SSD-61775465
D157/24
JD6 (CPE)

Re: STATE SIGNIFICANT DEVELOPMENT – REQUEST FOR ADVICE

SSD-67175465 – Mod 3 – 173 Walker Street North Sydney

DRAWING NAME:	SITEWORKS AND STORMWATER MANAGEMENT PLAN, SHEET 1
---------------	---

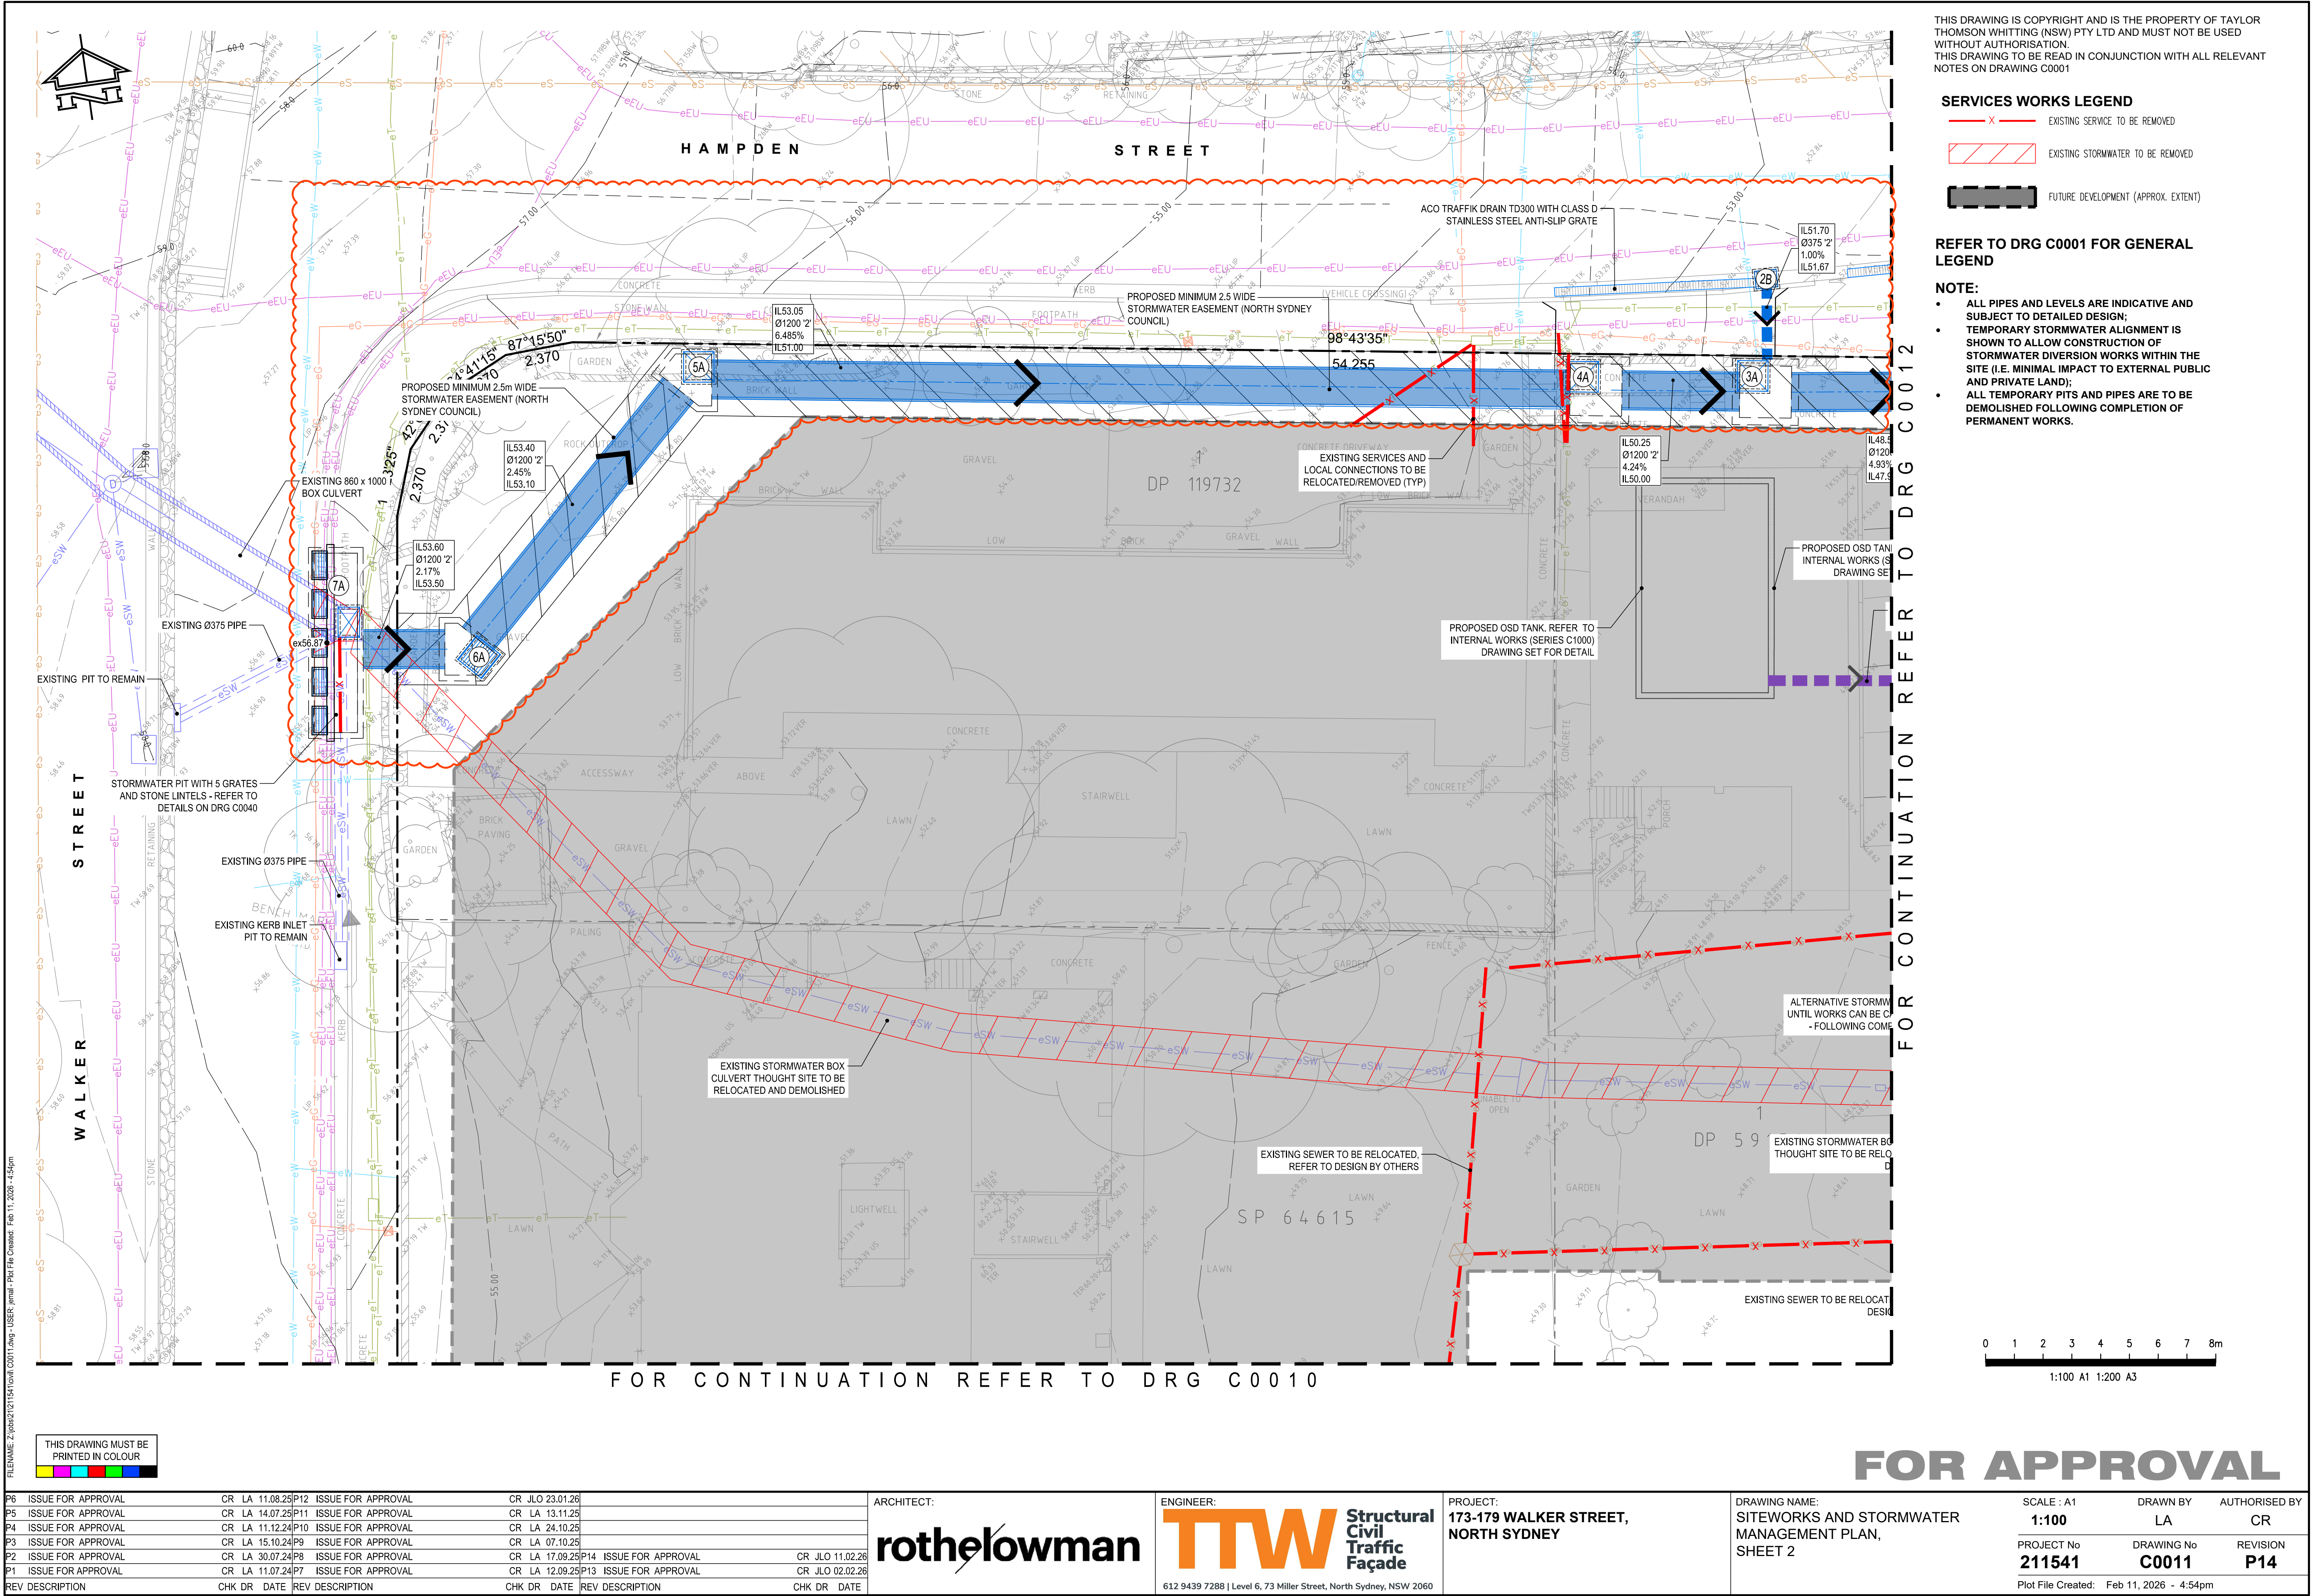
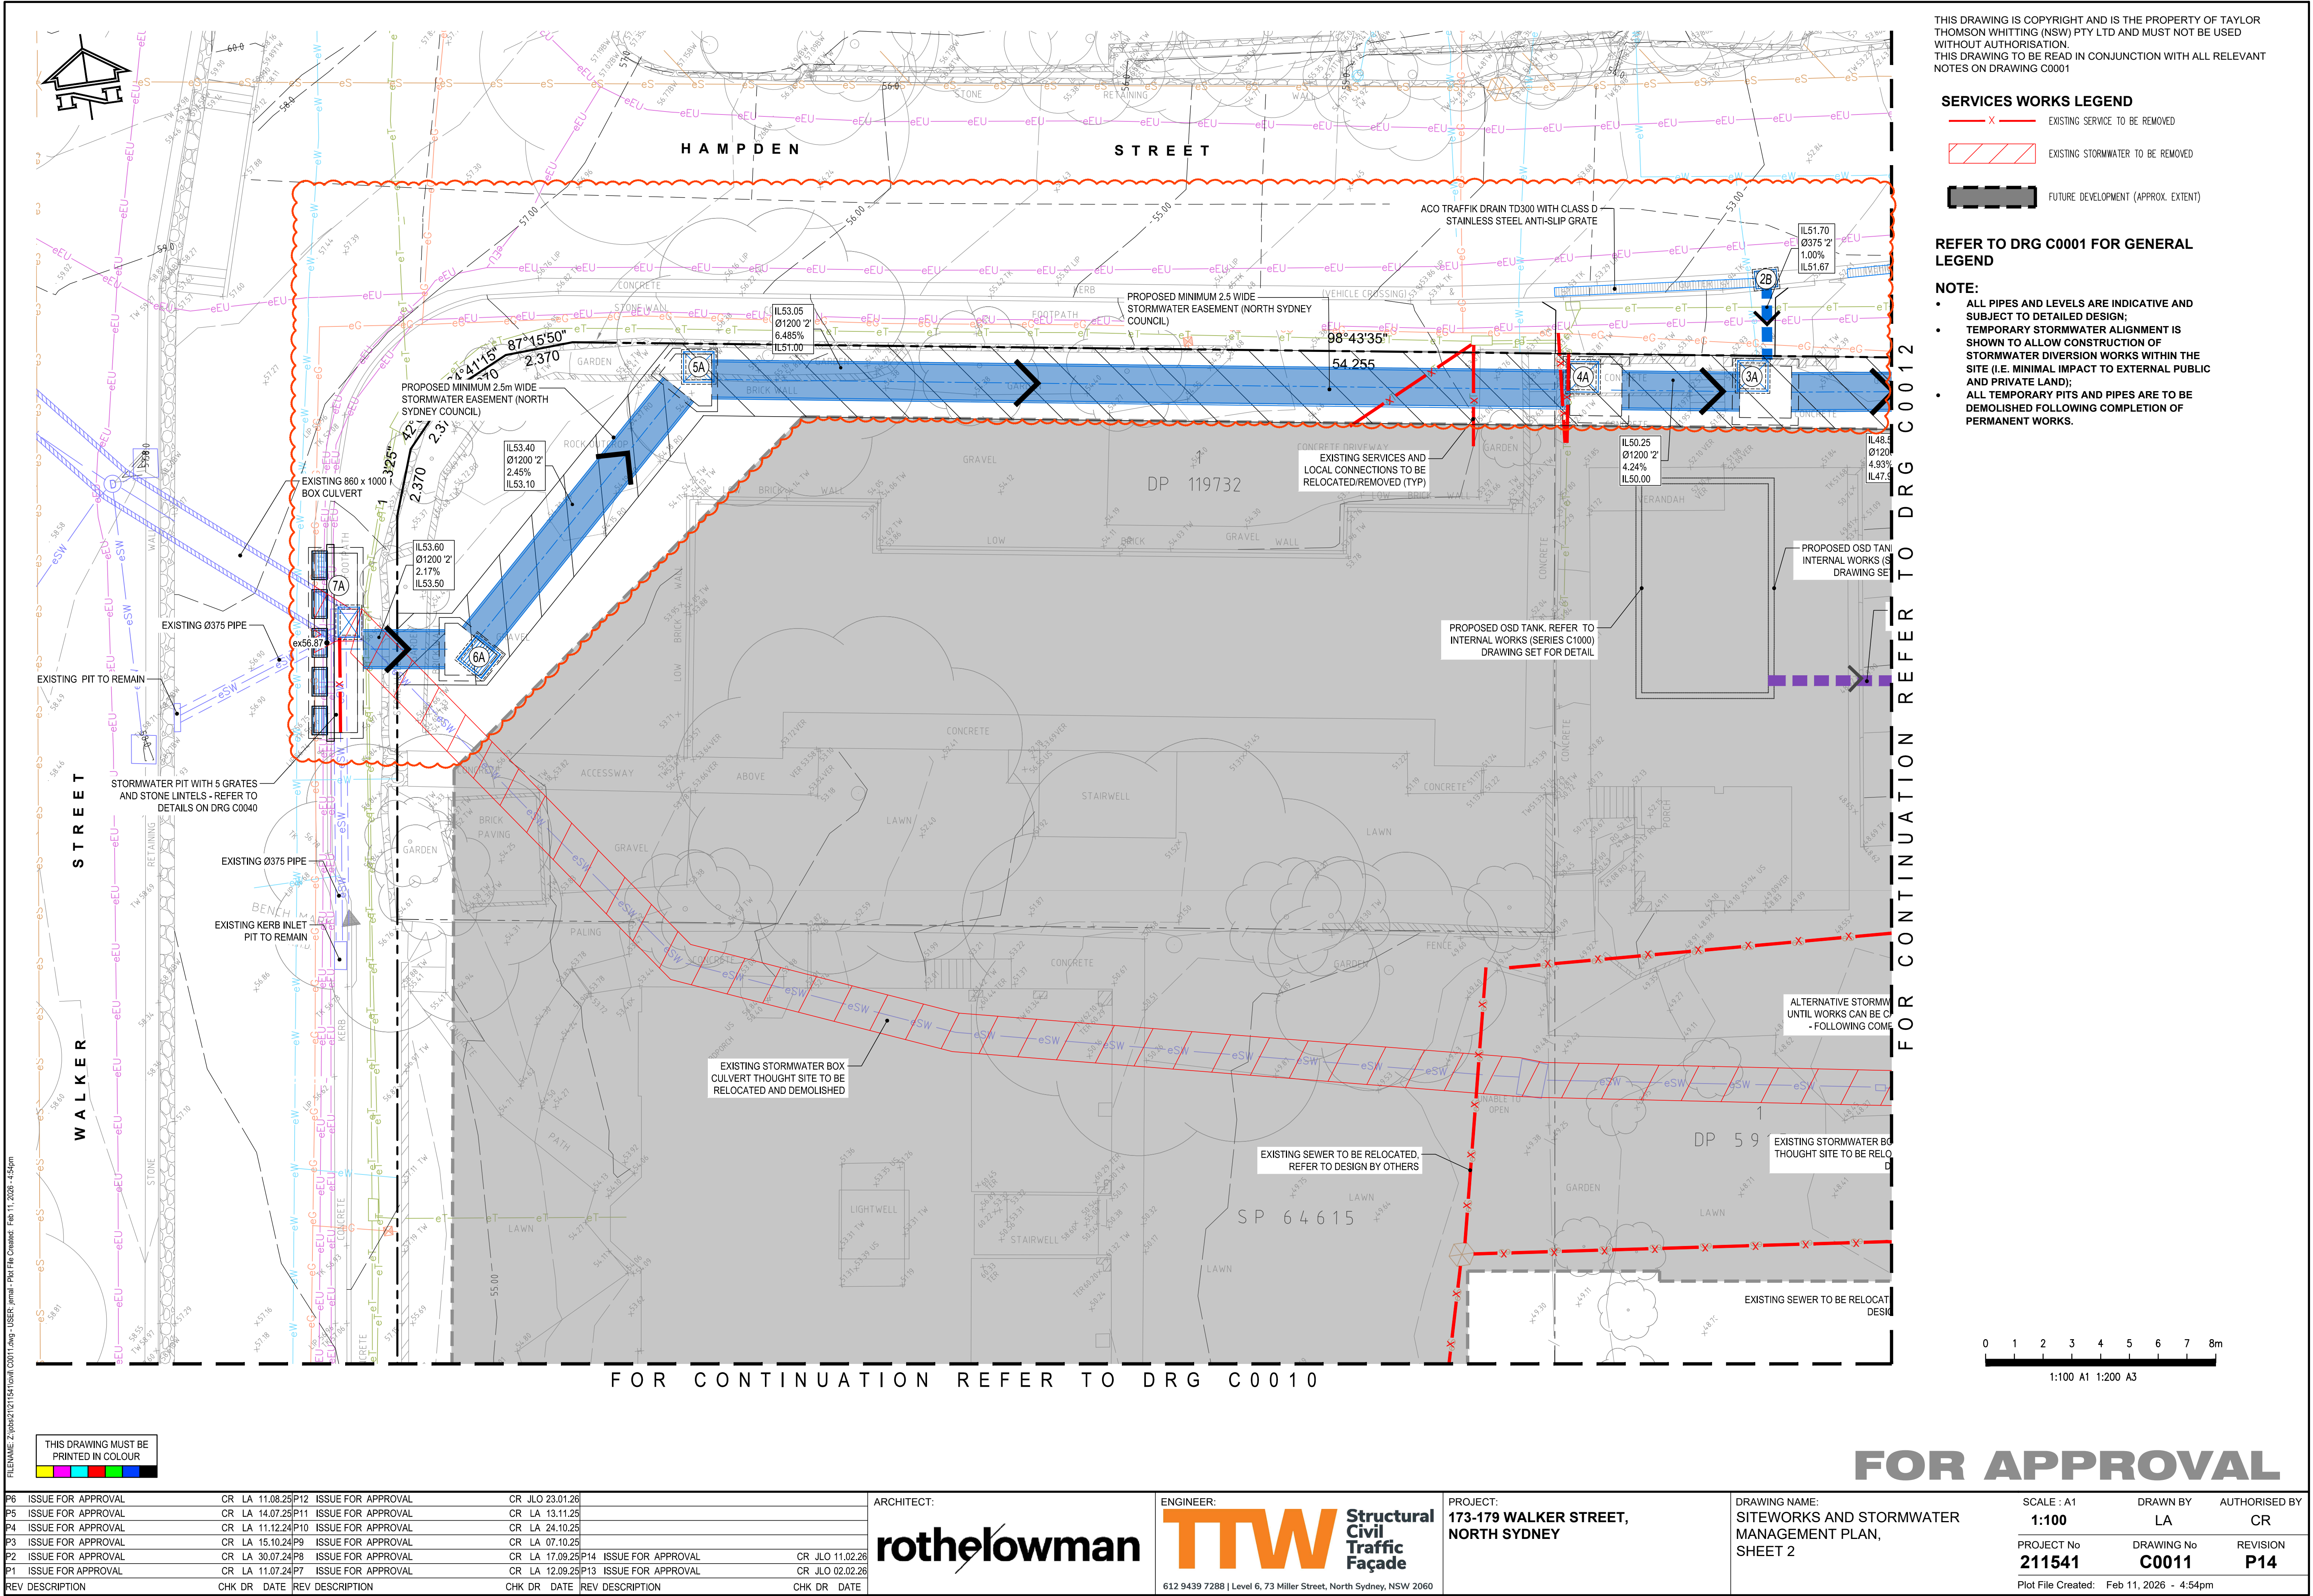
1. The revised design was not supported by Council in December 2025, when the applicant consulted Council about the matter.
2. At the time, the applicant was advised the amendment was unsatisfactory and that the approved design must remain.

3. The applicant was also informed that Council would require at least 800mm clearance from the basement walls to the stormwater pipe, to allow replacement of the pipe in the future and that any cantilever of the building would need to provide enough space to allow the pipe to be replaced if needed.

4. Additionally, the pipe is to be clear of all structures. The modifications submitted do not reflect these requirements and will make future maintenance and replacement more difficult and result in additional expense for Council.
